**Application:** 21/01116  
**Location:** Land On The West Side Of Albert Road Deal CT14 9RB  
**Proposal:** Variation of condition 1 of reserved matters application 18/00892 to allow for redesign of retail and residential block (approved units 1-8) to a create a block of 25no. apartments; amendment of 5no. blocks totalling 42no. apartments at west of site (approved units 96-99, 104-114, 115-125, 126-133 and 134-141) to create 22no. houses and 370sqm retail unit with three flats above; realignment of terrace of 2no. houses and 2no. apartments (approved units 92-95) to create terrace of 4no. houses; and substitution of house types for 12no. houses (approved units 84-91 and 100-103)

Please find enclosed an application under Section 96A of the Town and County Planning Act 1990, in respect of a proposed Non-Material Amendment (NMA) to the above s73 planning permission.

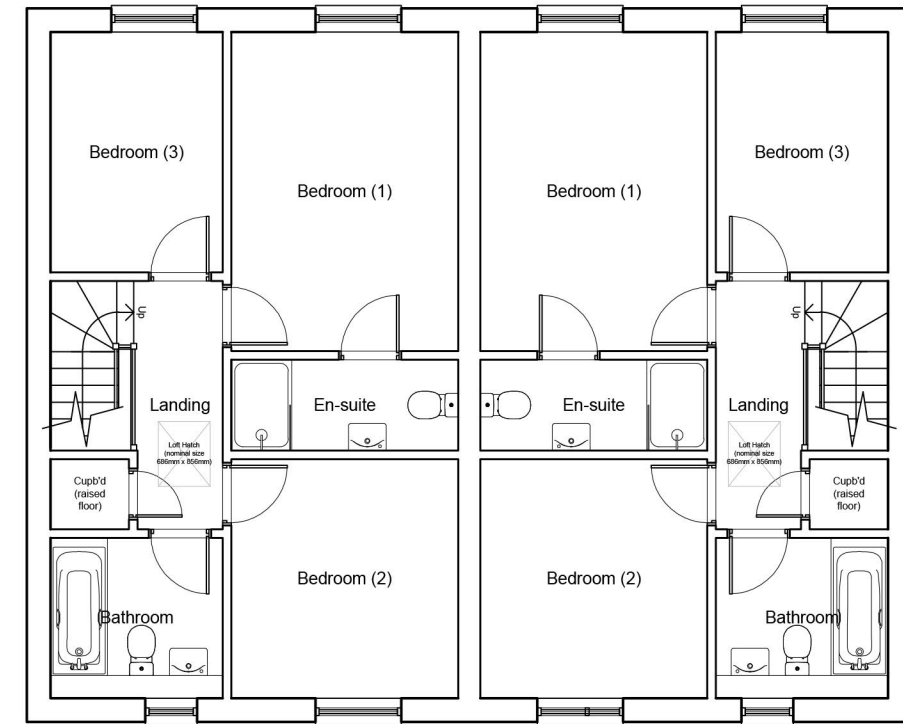
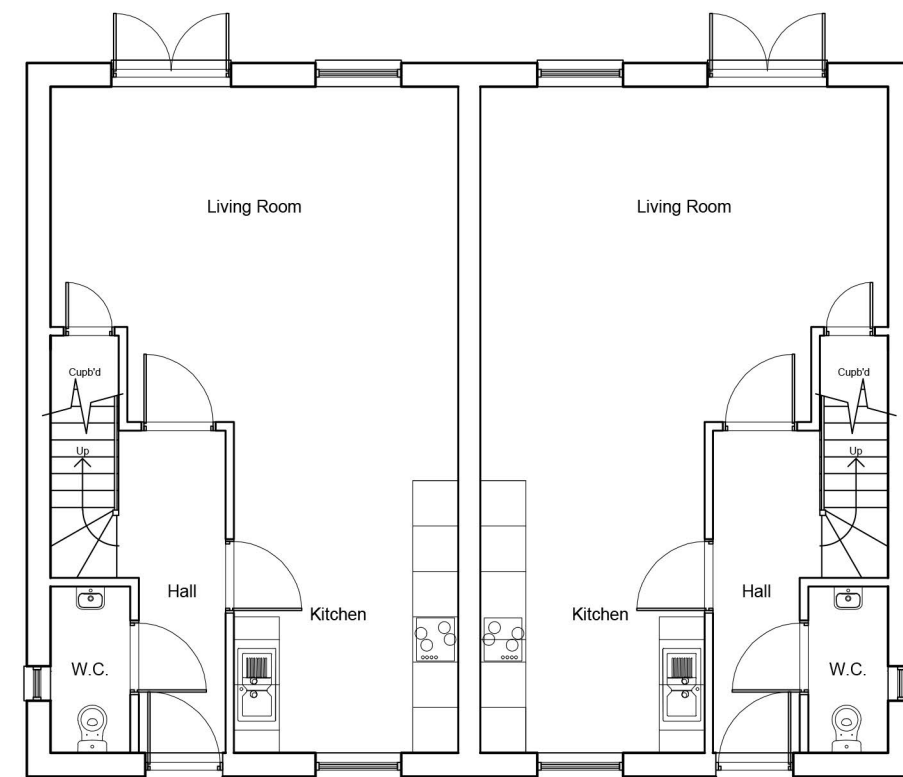
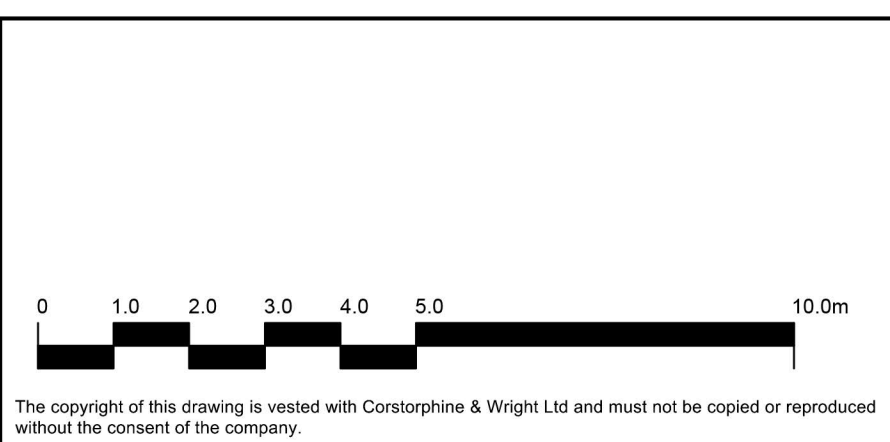
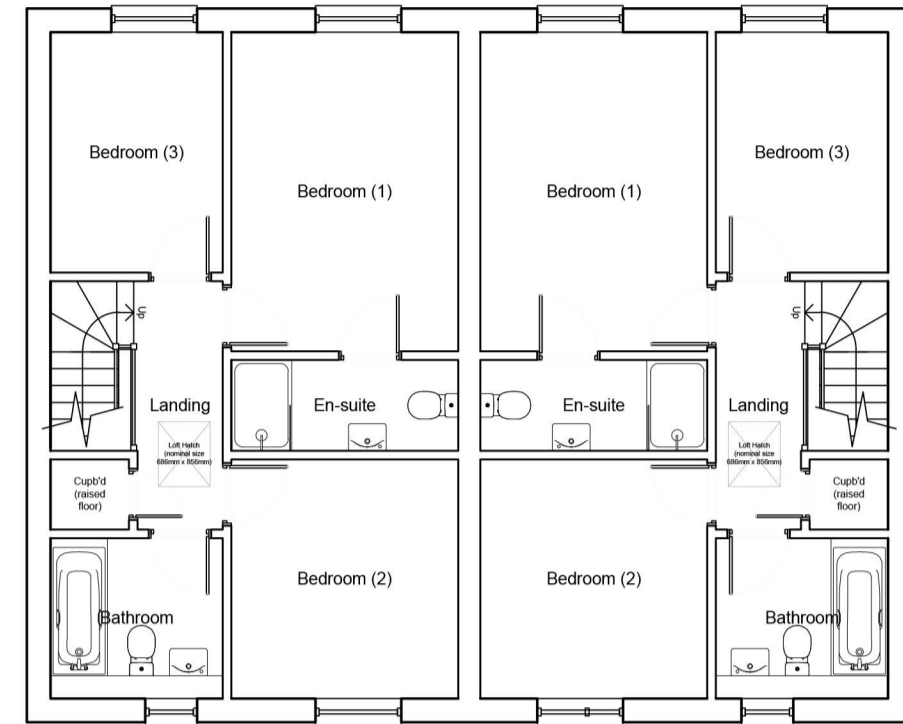
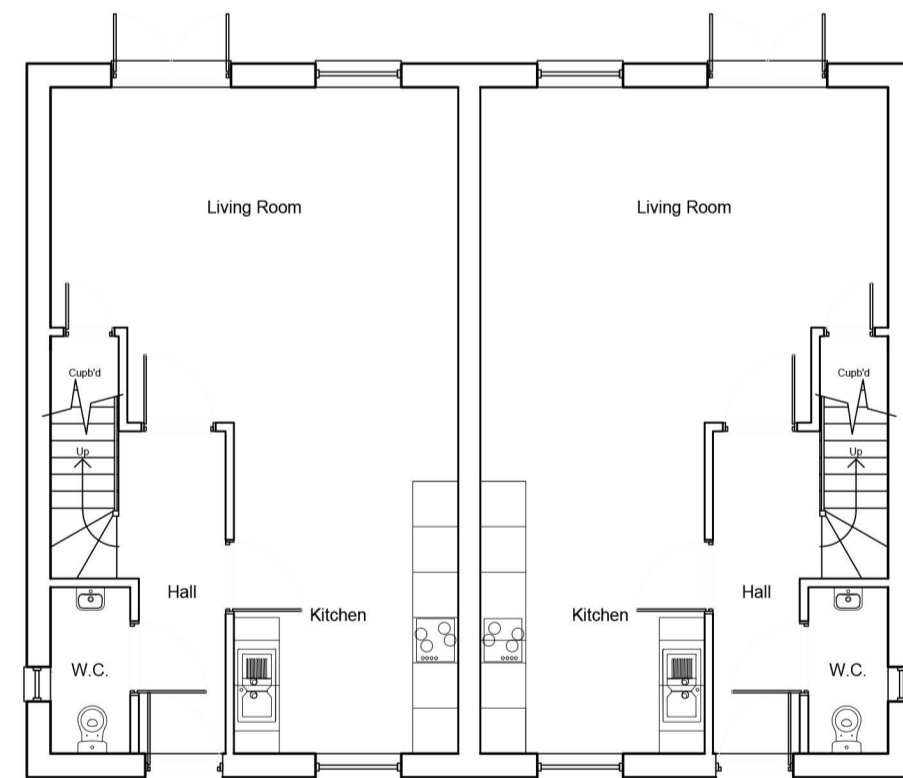
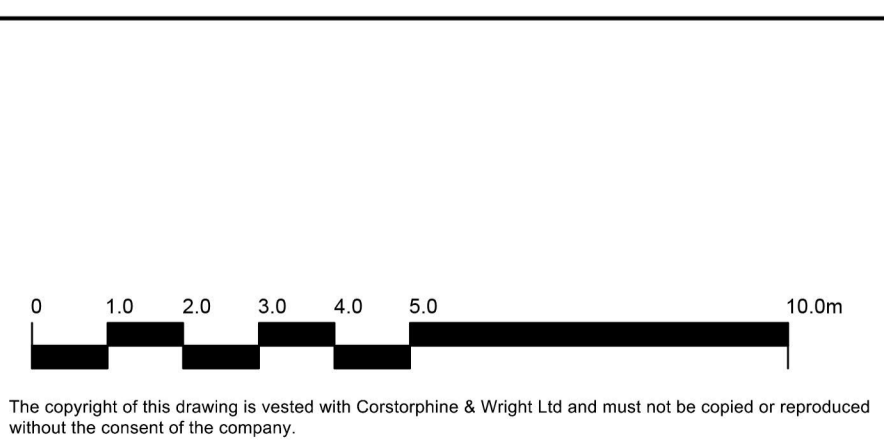
The amendment seeks to make minor amendment to the design of approved plots 117 and 118 comprising a of semi-detached townhouses. The amendment would see the external treatment amended from brick to white weatherboard. The application is accompanied by the approved drawings and by those now proposed.
